**Halcrow MWT**

26 November 2009

As requested we have reviewed comment made in relation to the proposed design by different authorities. We discuss the ones related to traffic below.

Basement 1

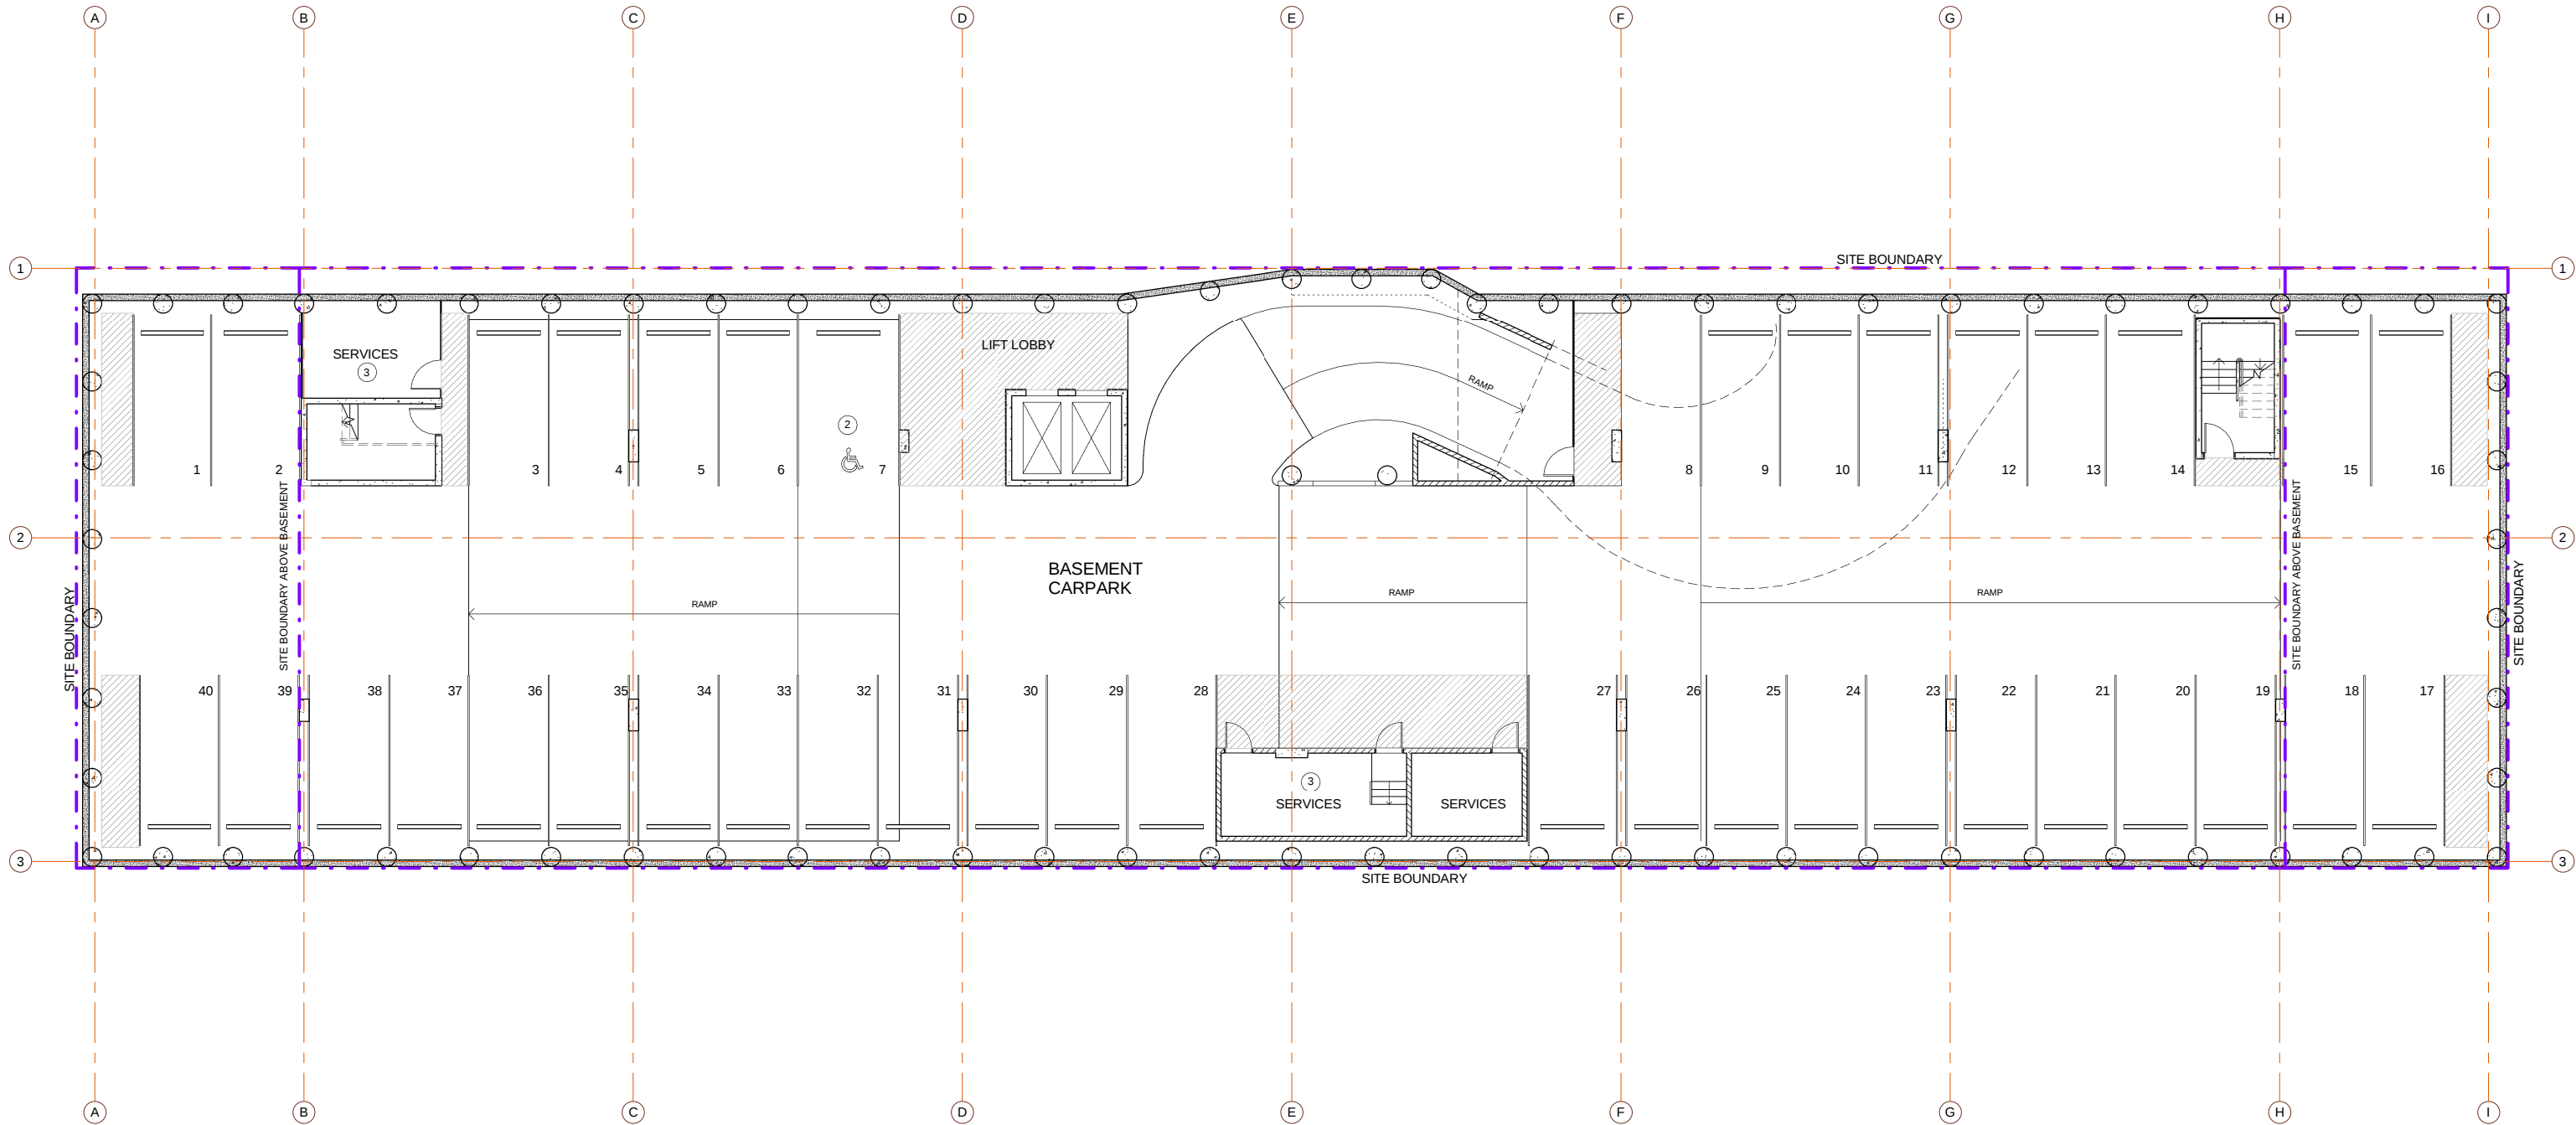
Basement parking to have 3% accessible spaces and ground level parking on accessible space – these are provided.

1 Ground Floor
04 1 : 100

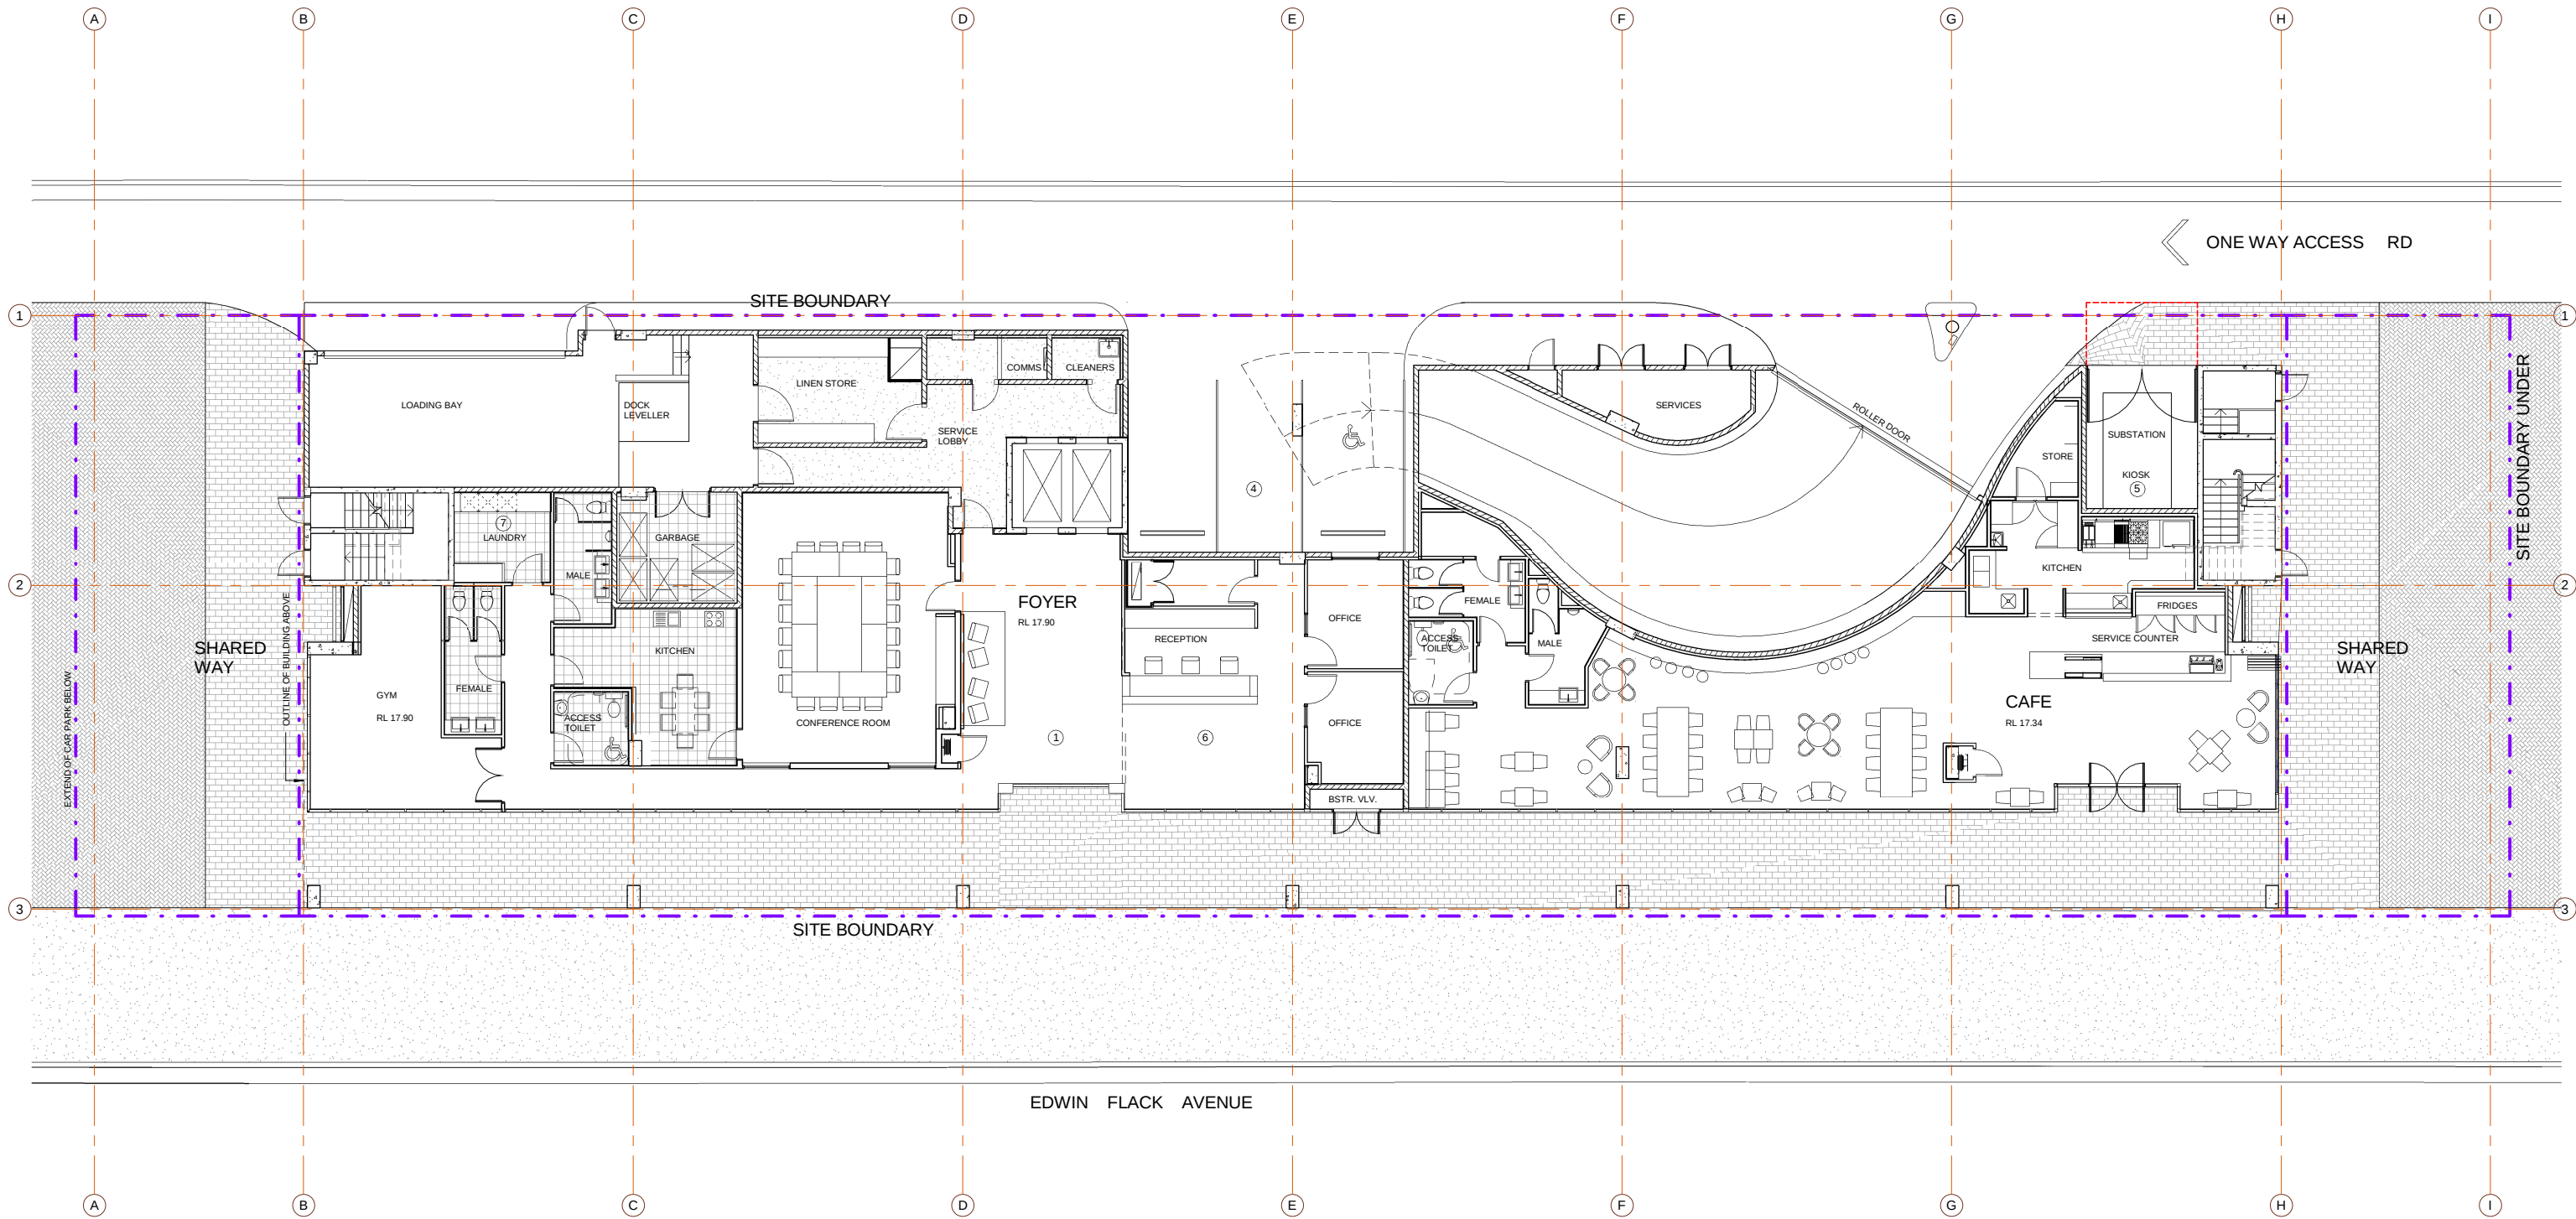
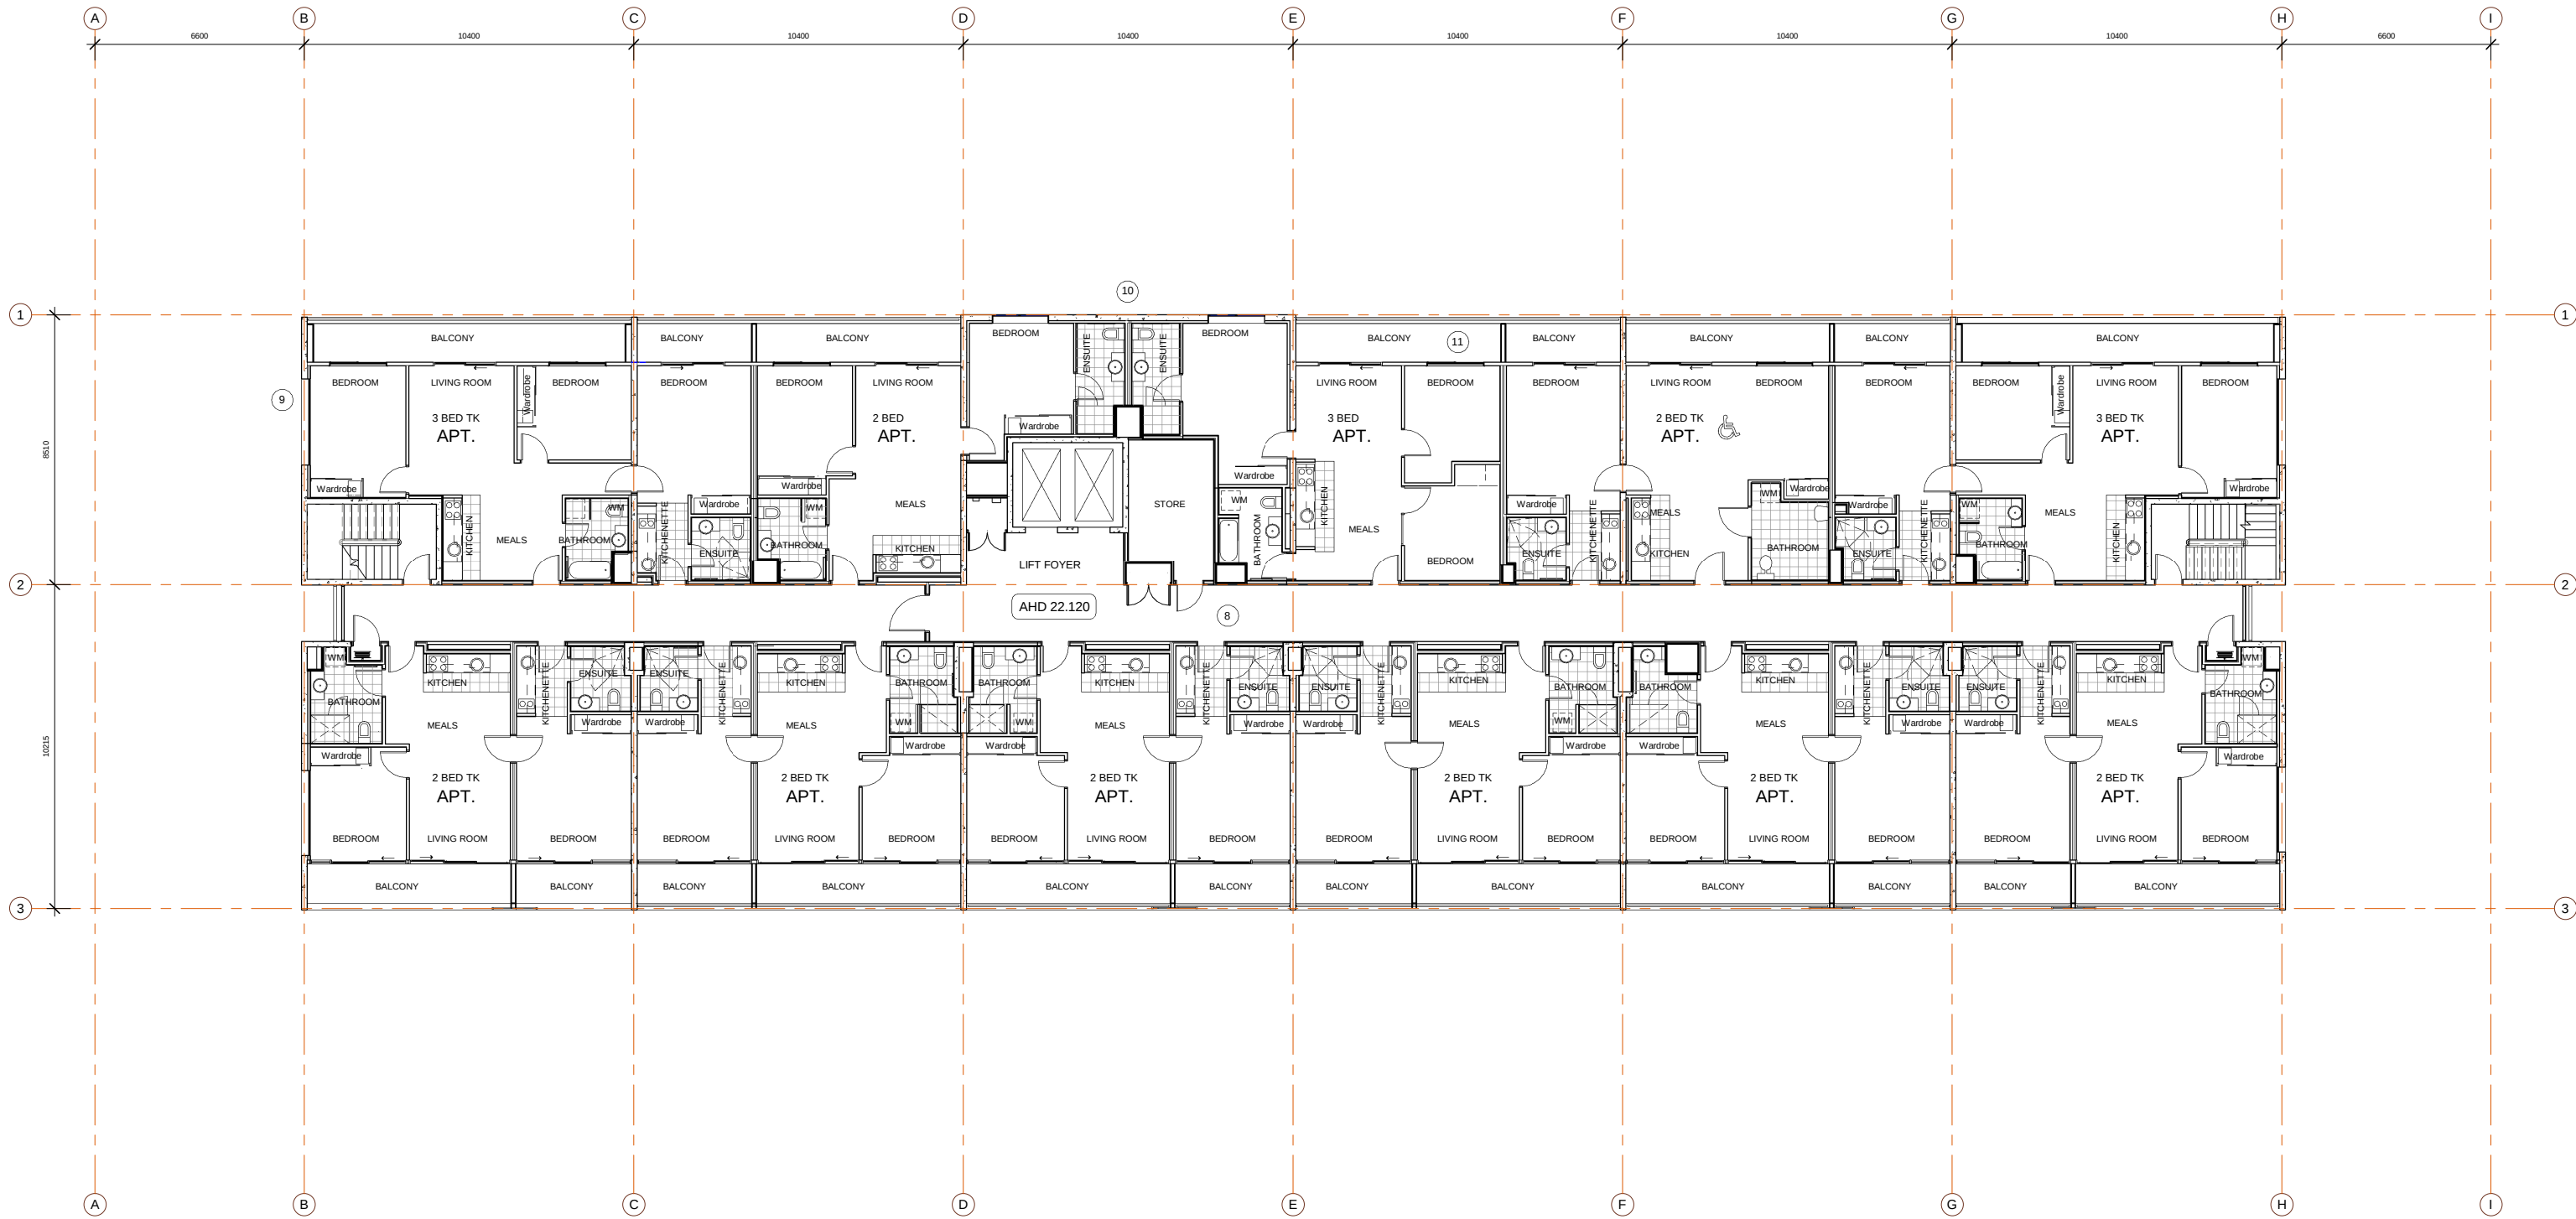
- Loading area for service vehicles plus a pedestrian connection from this to the tenancies is required – as indicated above these are now incorporated in the design.

- Loading bay should be provided – now incorporated in the design.
- At grade car parking does not look like it complies with the Australian Standards – It is proposed that the layout comply with Australian Standards and recommend that this be a condition of consent.
